From: [REDACTED]
Sent: 29 February 2020 10:30
To: Sian Eggington
Subject: Long Gables, Gorse Avenue, East Preston - K/8/20/HH
Attachments: We sent you safe versions of your files; PROPOSALS 03C.pdf; PROPOSALS 04C.pdf; PROPOSALS 05B.pdf; PROPOSALS 06C.pdf; SITE PLAN A.pdf

I would suggest the revised planning description to read '**Remove existing 1st floor structure on front balcony and replace with new French doors. Rebuild existing front porch and extend forward to match line of front of property. Replace existing 1st floor balcony railing with new toughened glass panels**'.

Proposals 04 C

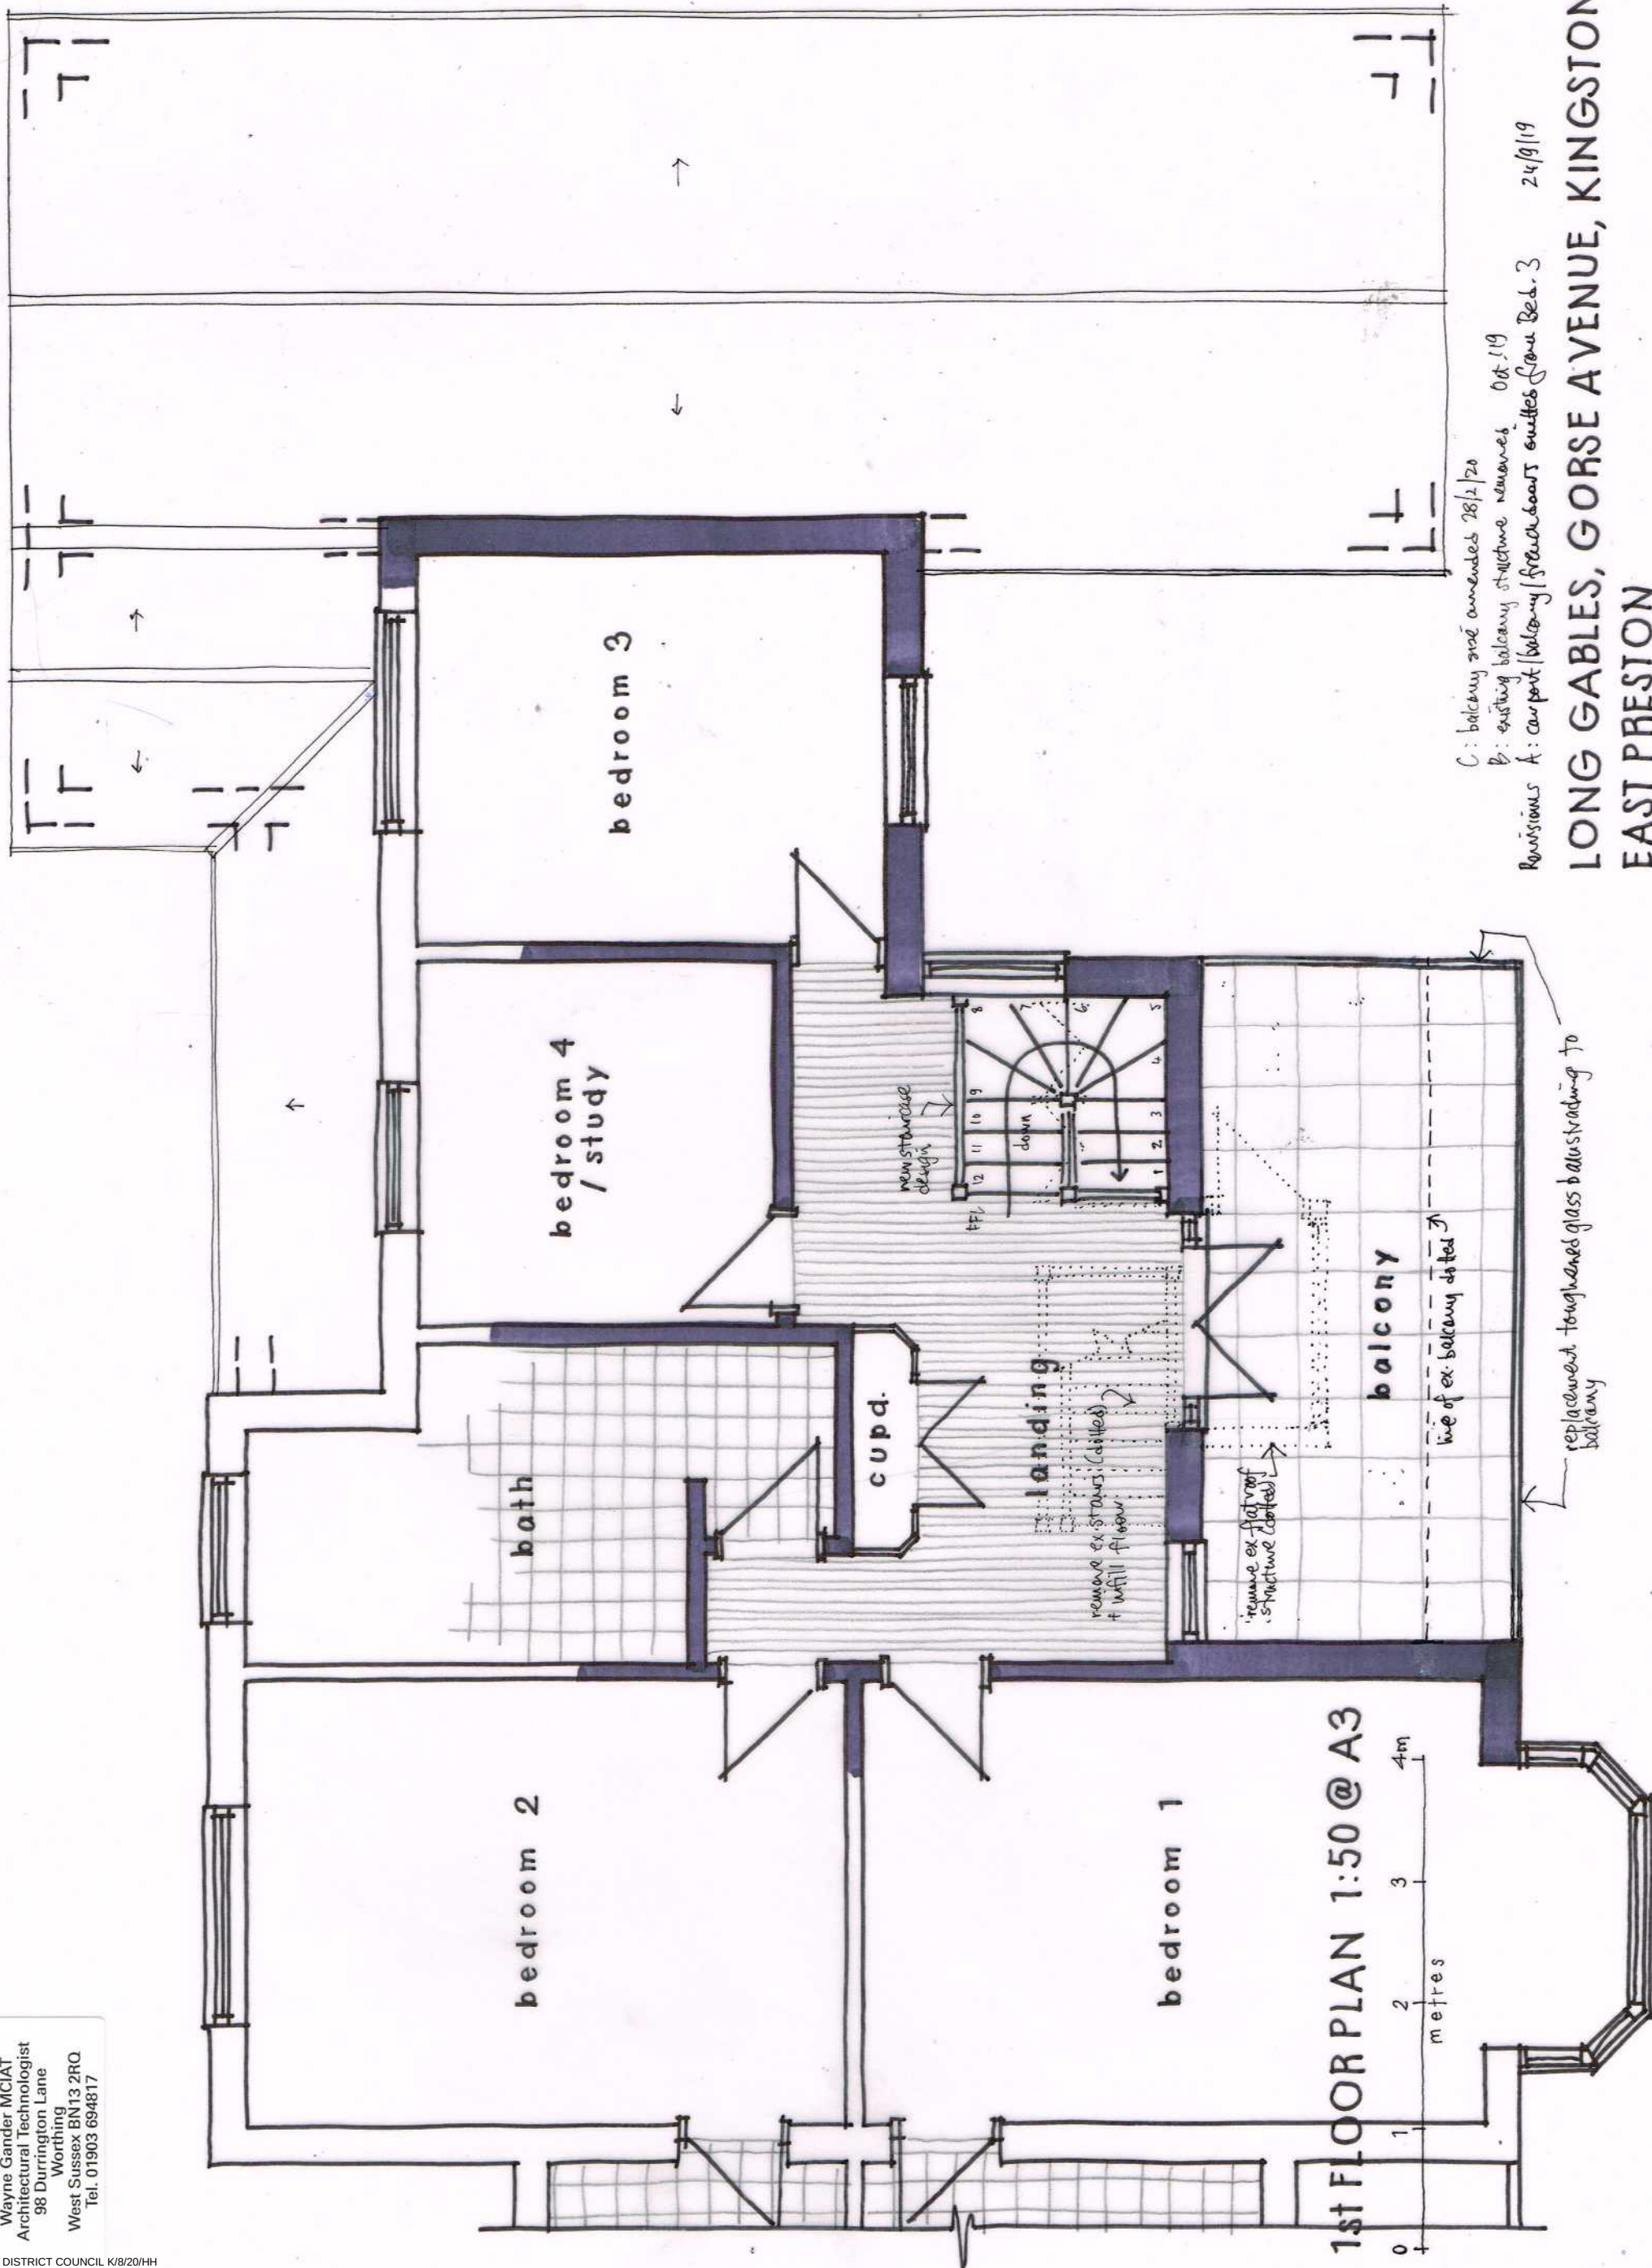
In addition the applicant has asked for the porch to be brought forward to the line of the house thus resulting in a larger 1st floor balcony, please see attached revised drawings 03C, 04C, 05B & 06C.

LONG GABLES, GORSE AVENUE, KINGSTON GORSE,
 EAST PRESTON
 Proposals 05 B Aug 2019

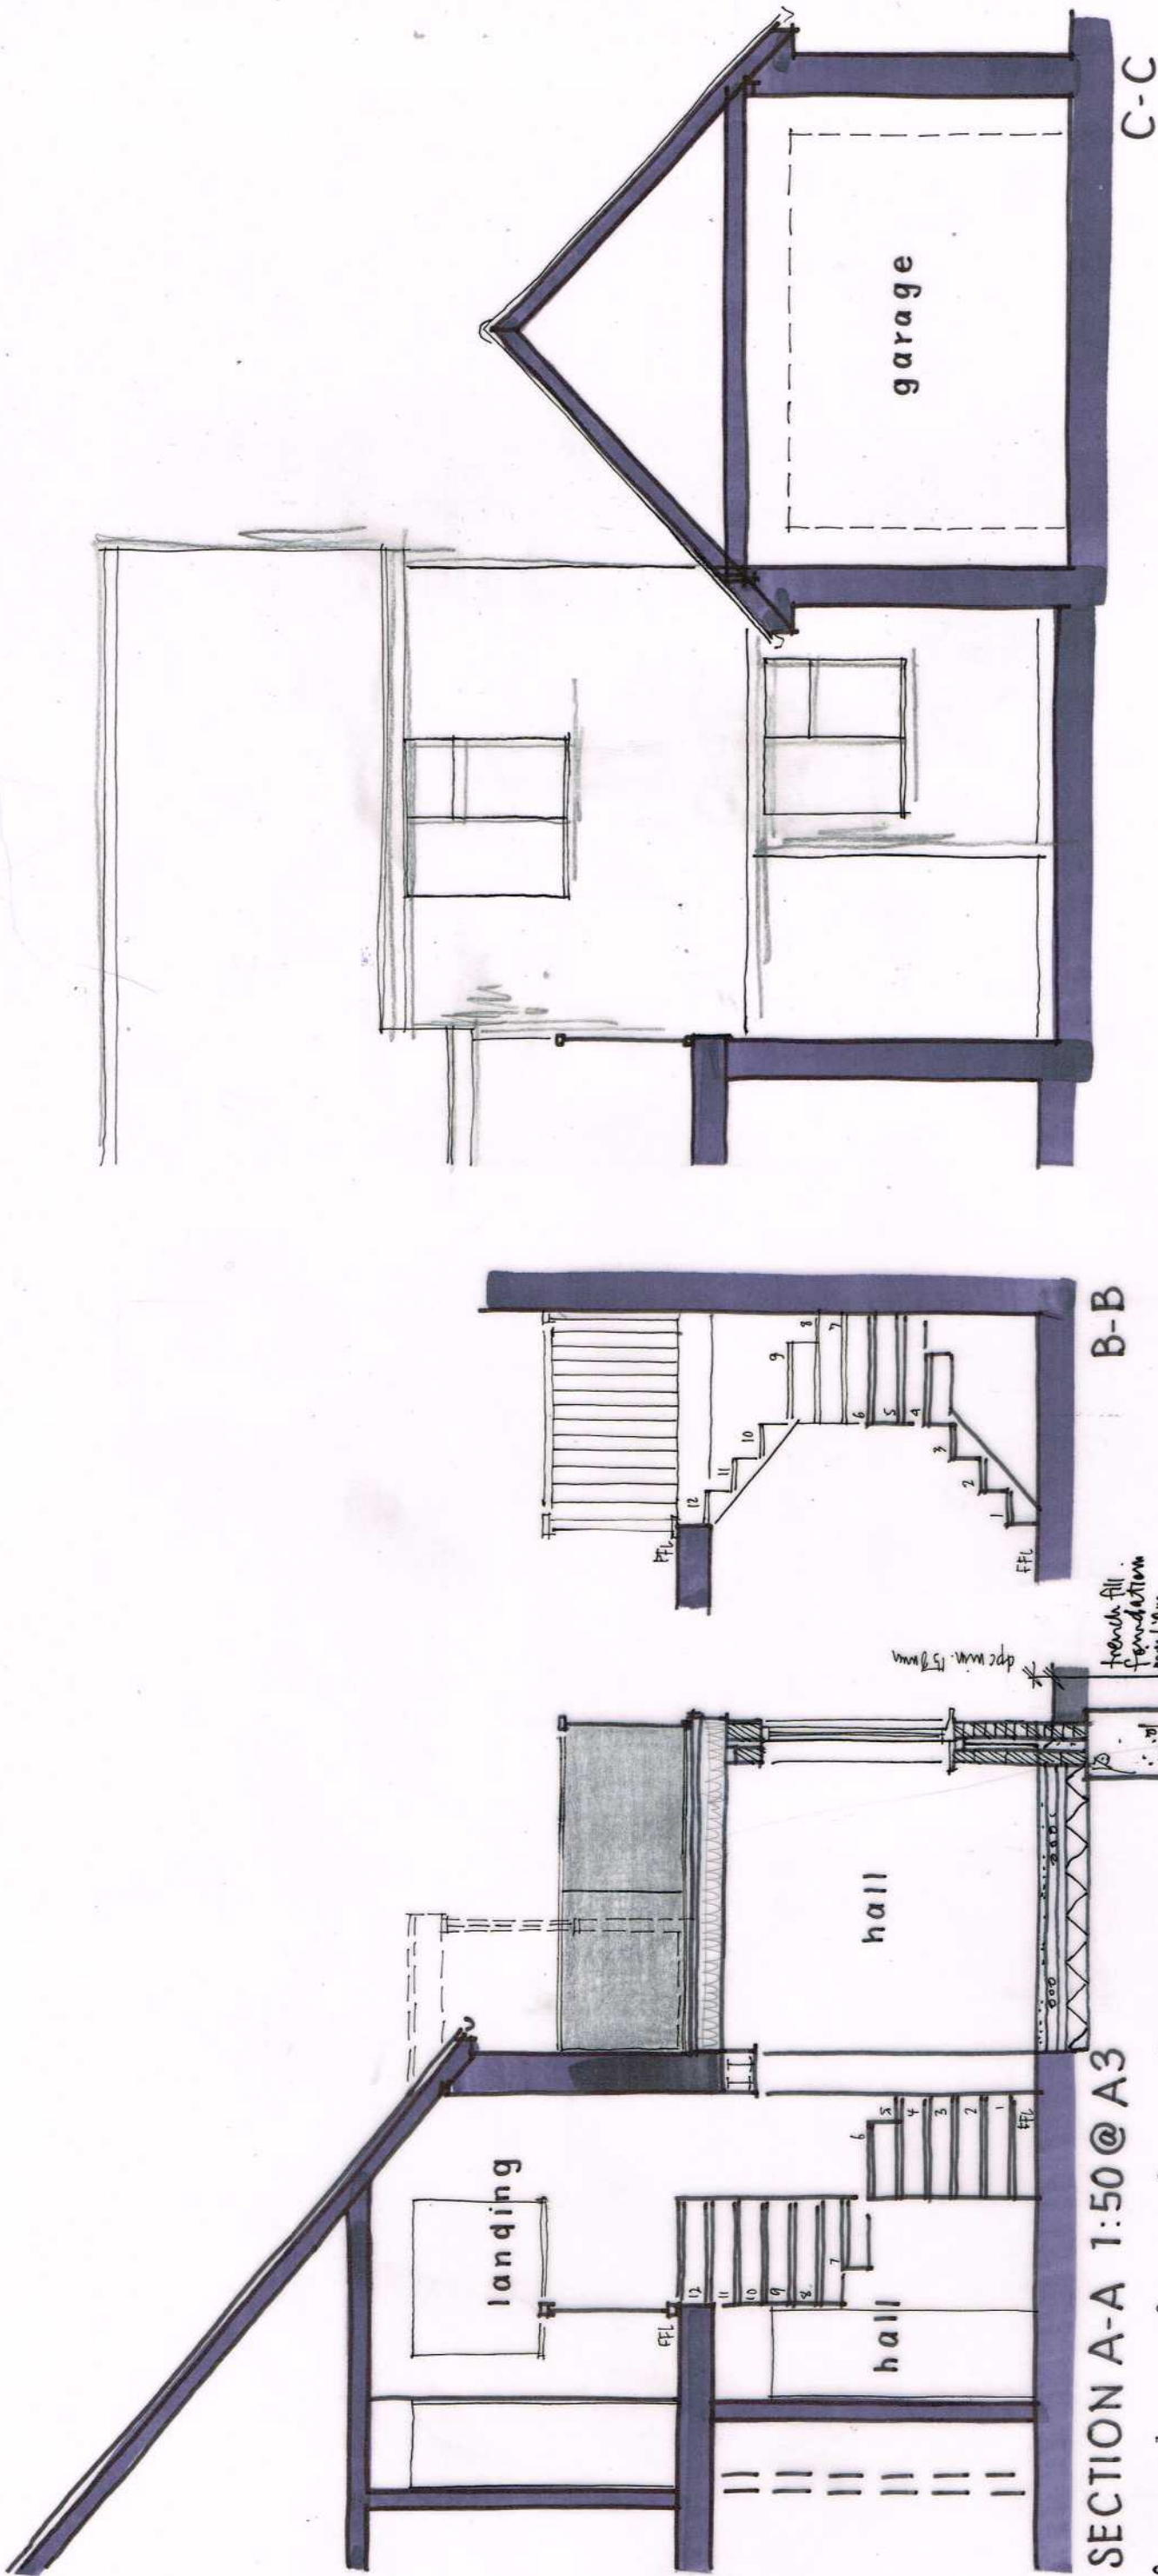
Further to your letter of 27/2/20 via Nicola Spencer I am pleased to attached amended drawings including a section through the balcony.
